MERCY HOSPITAL

Statement of Deficiencies and Plan of Corrections

This inspection was conducted at the request of Mercy Hospital. This is not a Federal Health Care Survey. The building is a five story Type I(332 construction.

Date of Inspection: 25 August 2008
Inspector: Jon Klages

Drawing Title and Number  
 THIRD FLOOR CODE EGRESS AND  
 LIFE SAFETY PLAN

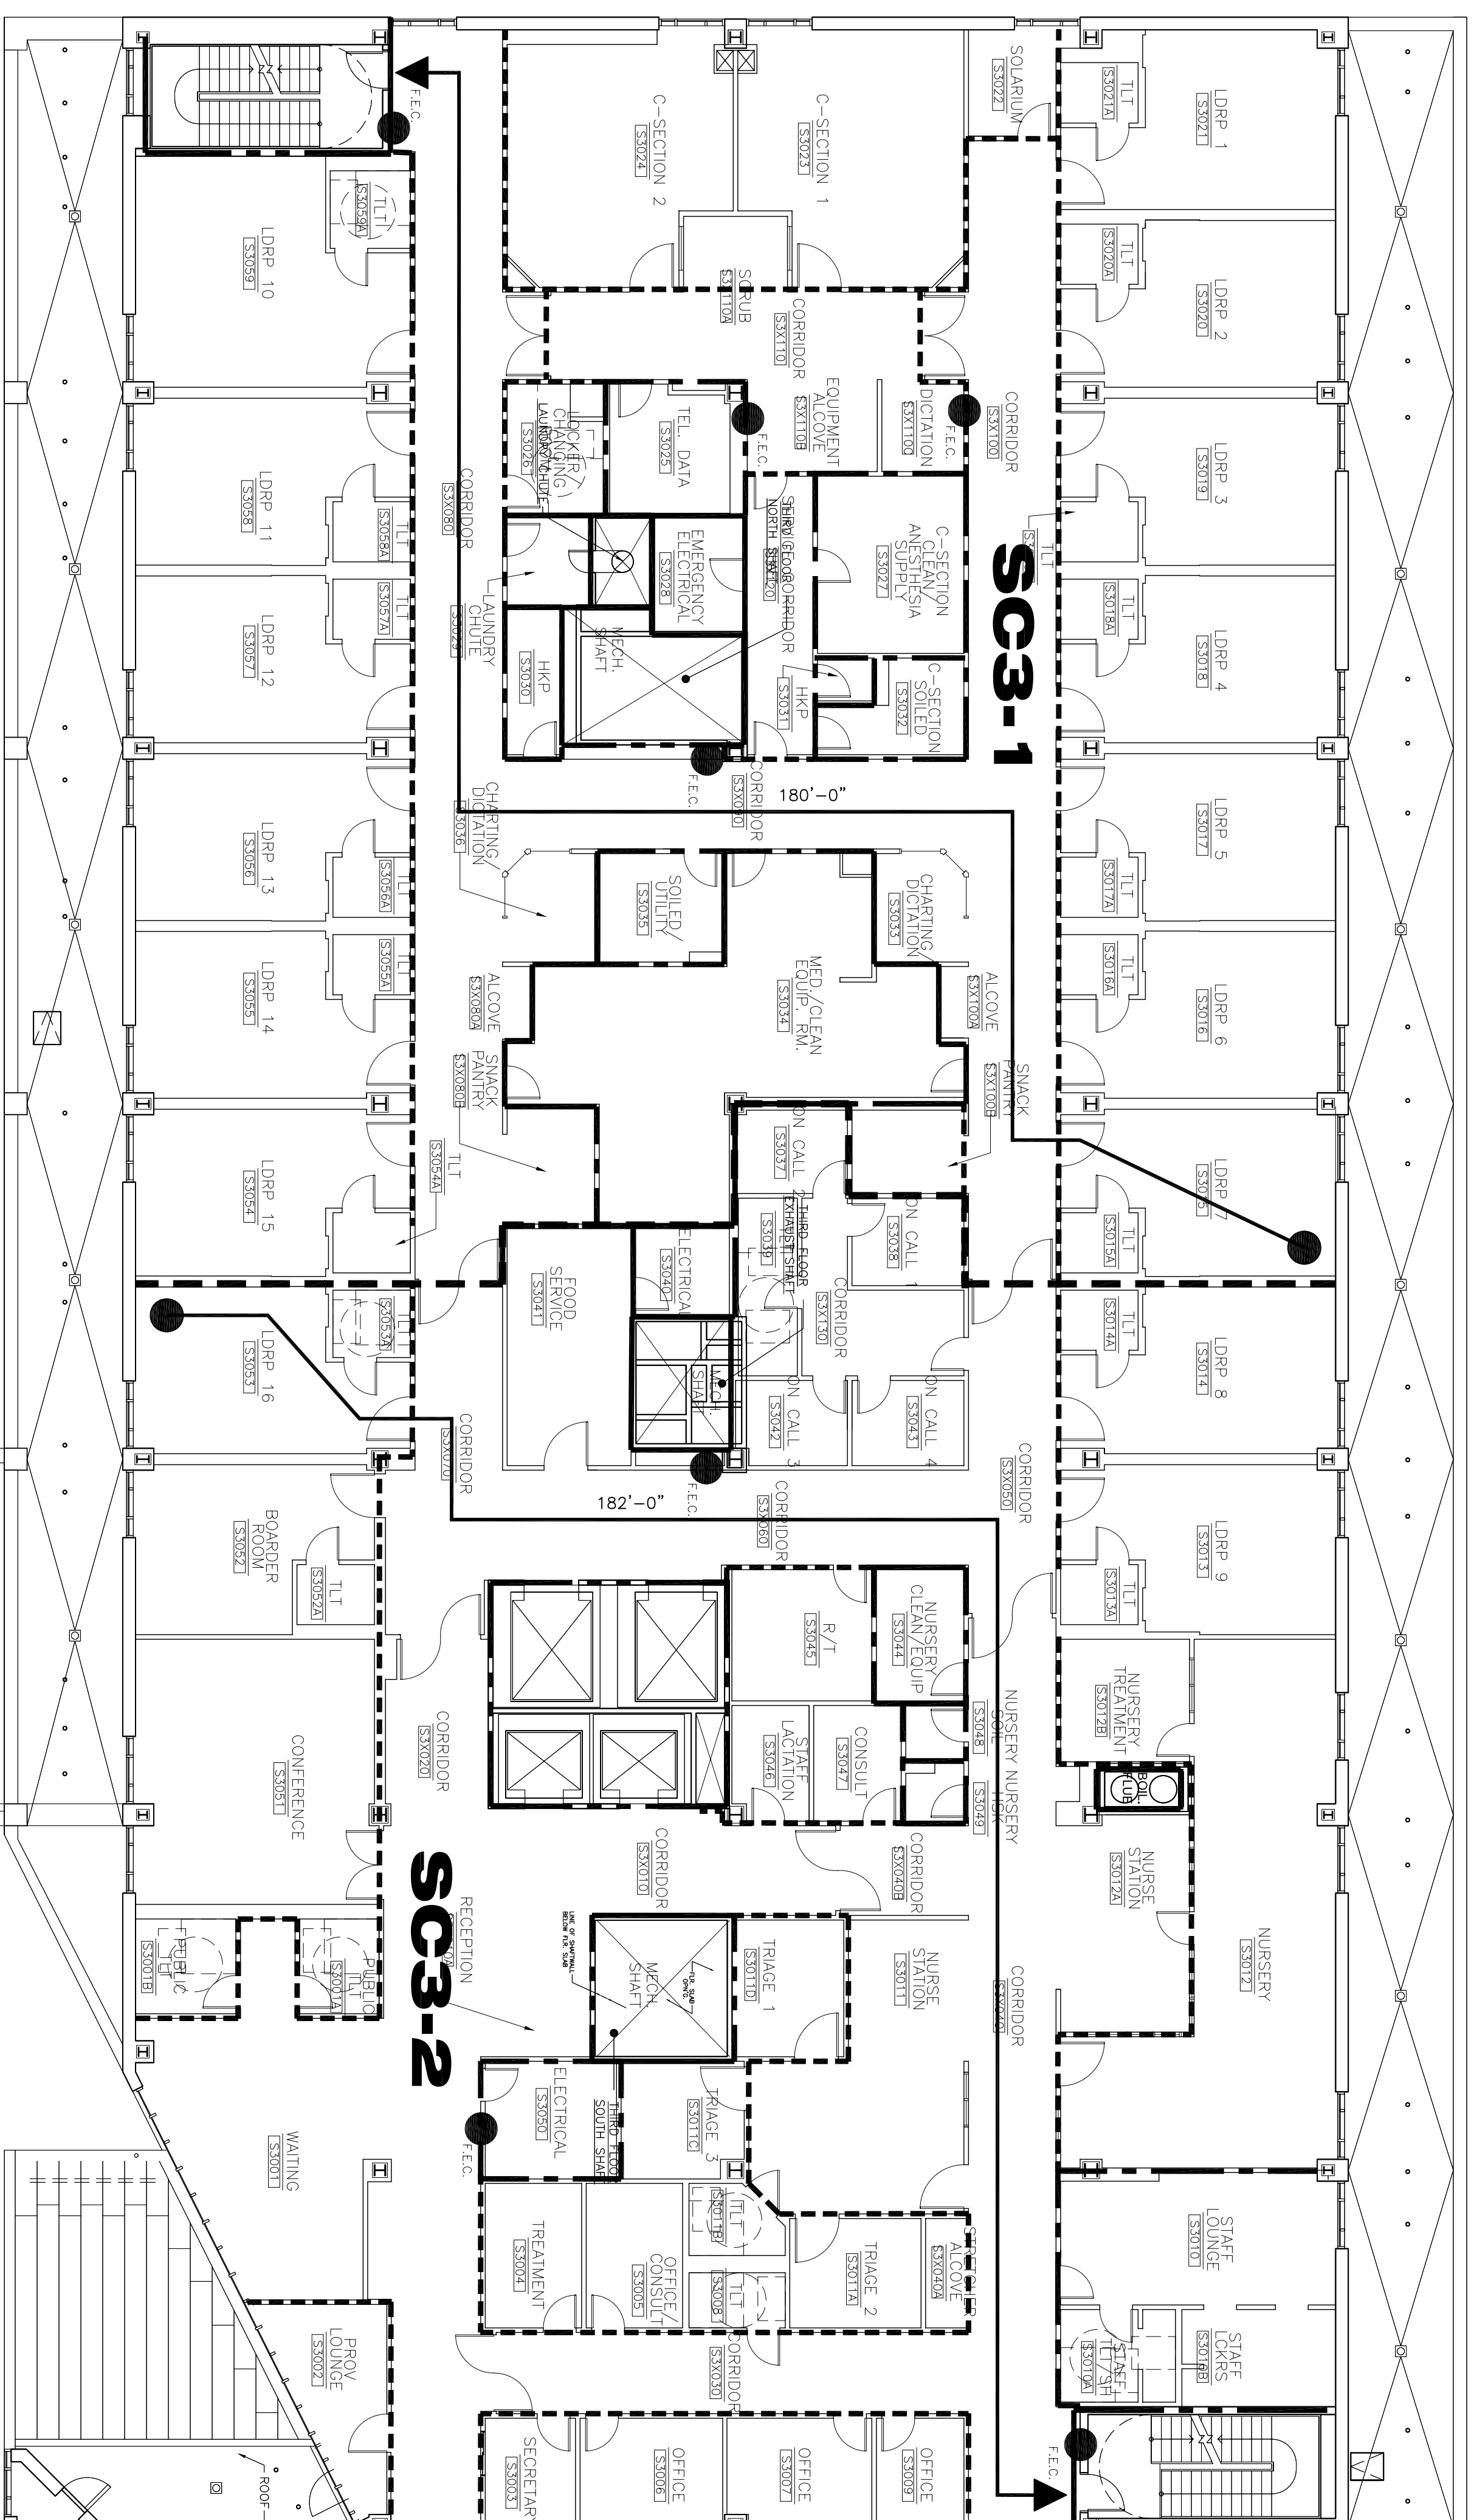
1. Repair steel beam with required fire spray to return beam to two hour rating in room S3025
2. Stair one-third floor repair penetrations in wall.

1. THIS ITEM HAS BEEN COMPLETED

2. THIS ITEM HAS BEEN COMPLETED

Drawing Title and Number
 FOURTH FLOOR EGRESS
 AND LIFE SAFETY PLAN
A0.04

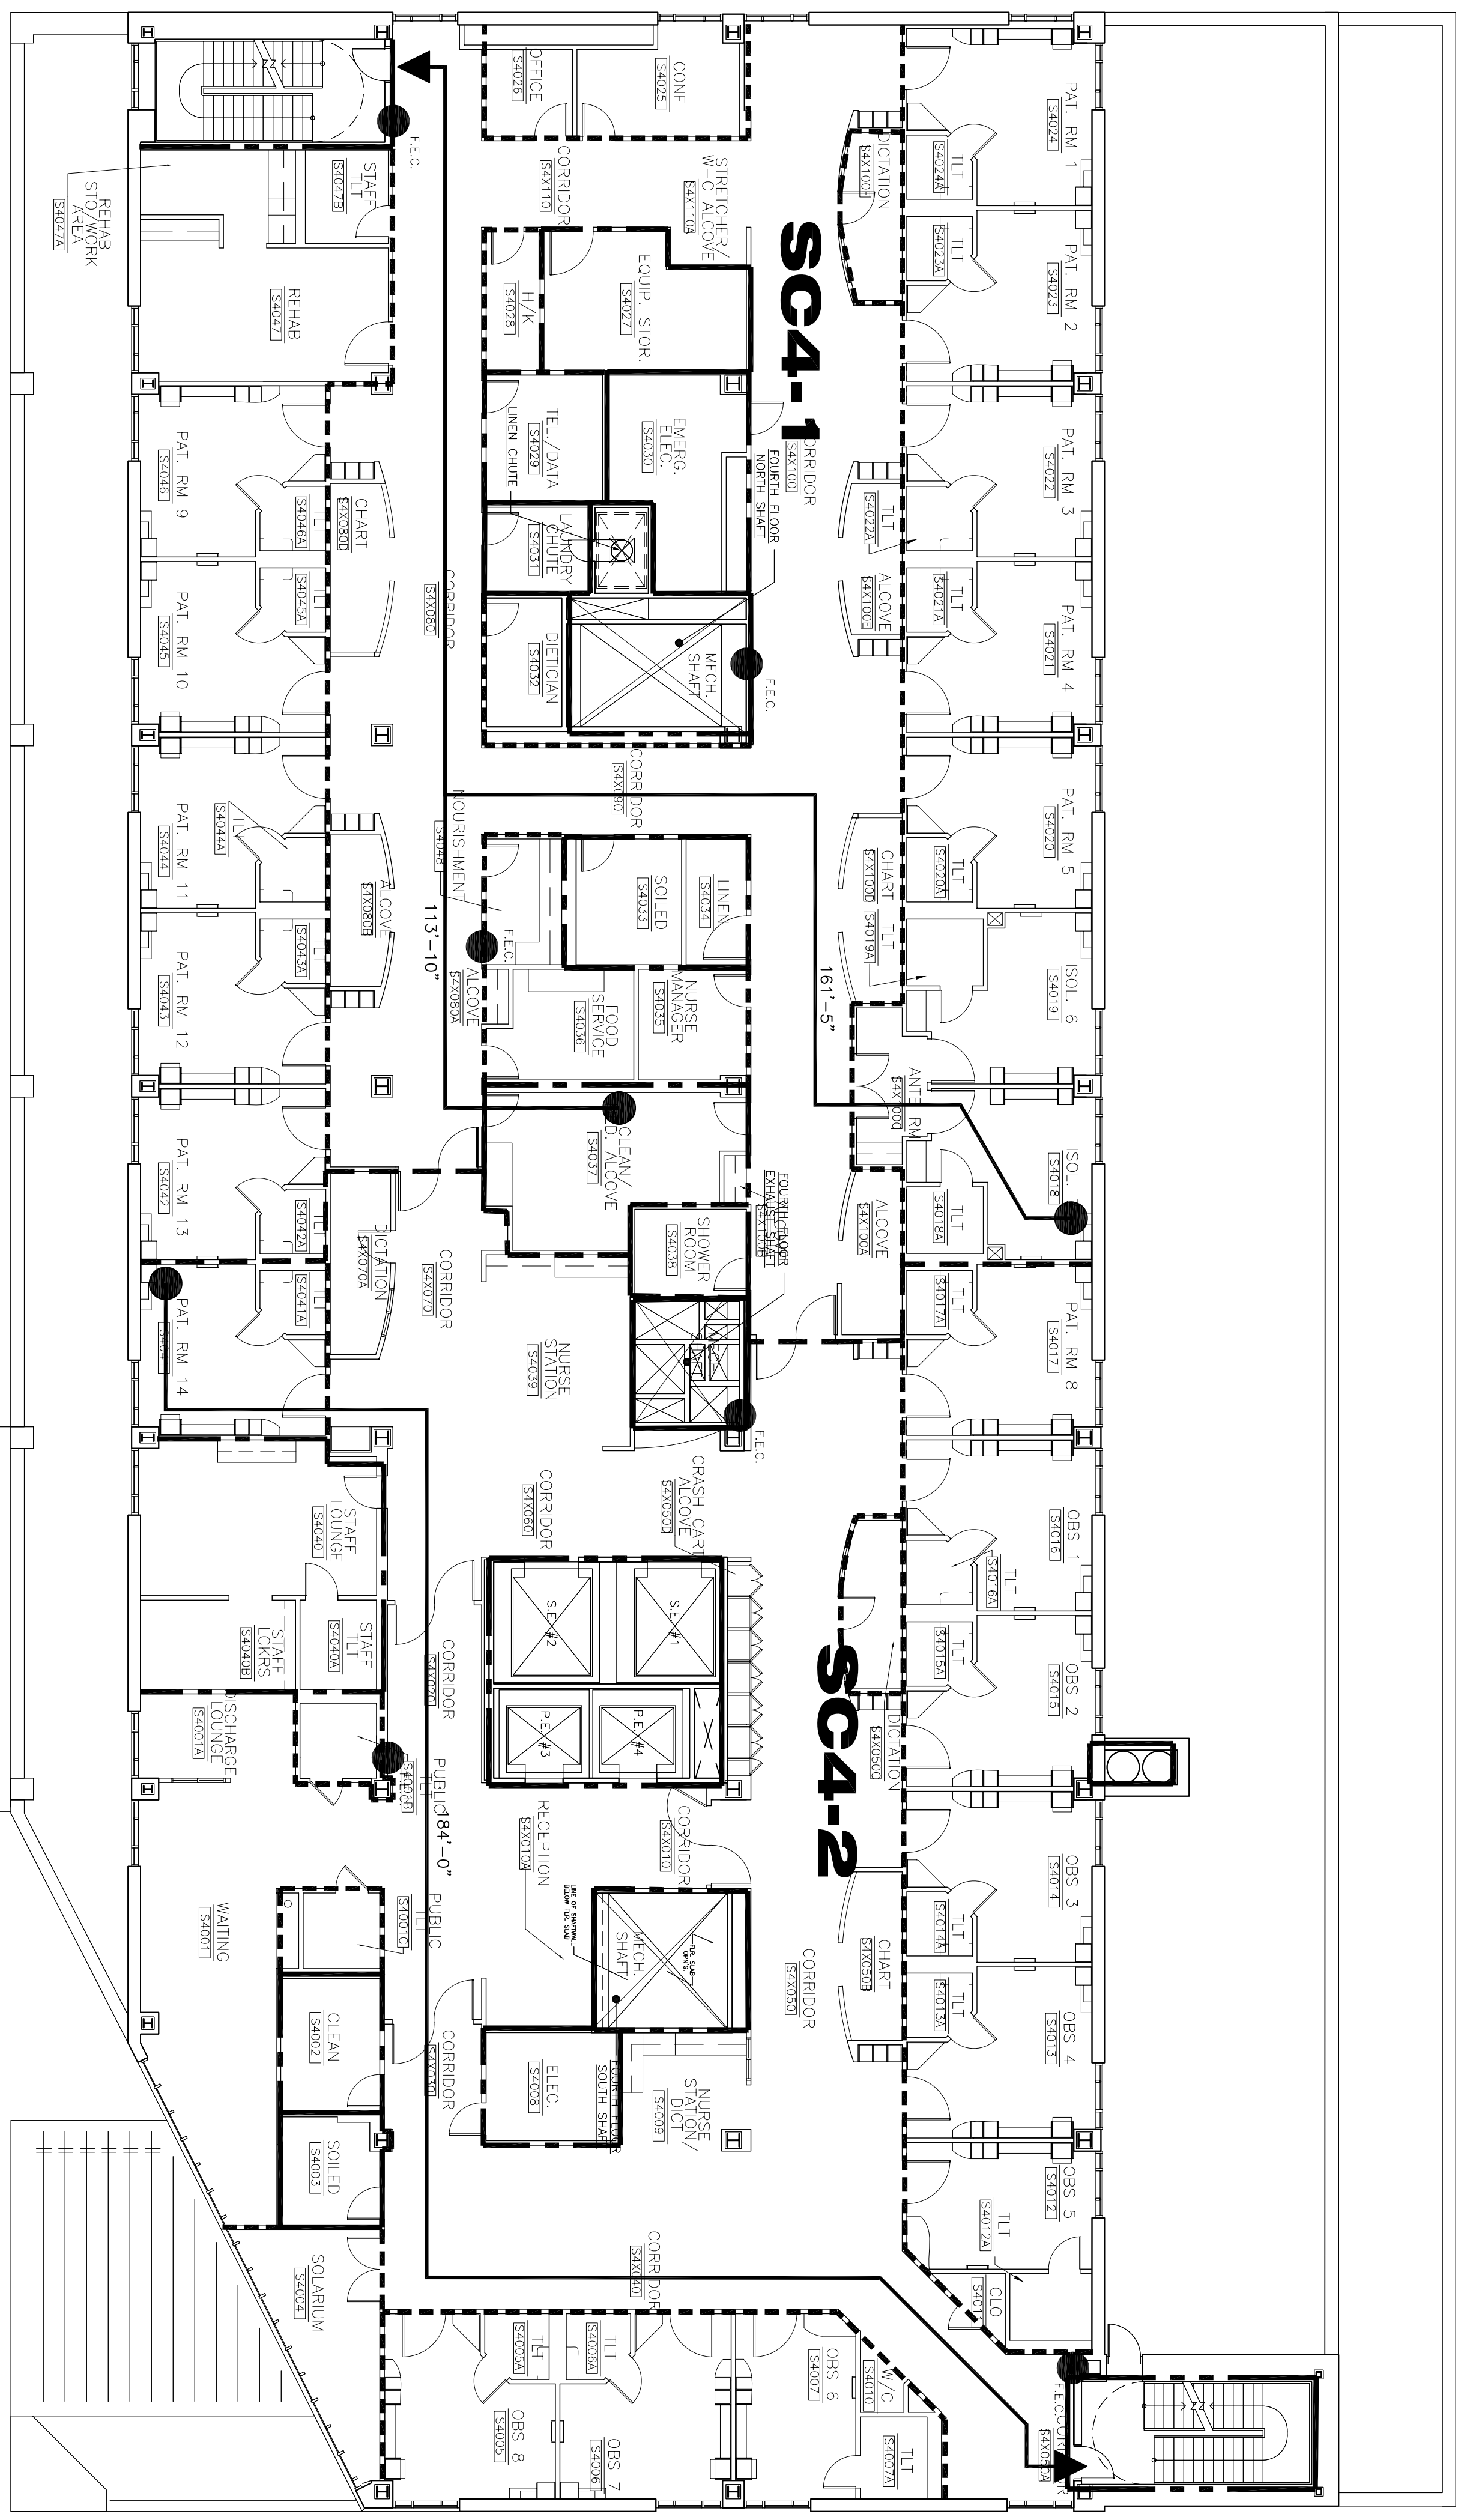
1. S4032 Repair walls to required rating
2. Repair smoke wall in room S4037 around pneumatic tube
3. In room S4040B repair 1 hour rated wall

1. THIS ITEM WILL BE COMPLETED BY 9/5/2008

2. THIS ITEM HAS BEEN COMPLETED

3. THIS ITEM HAS BEEN COMPLETED.
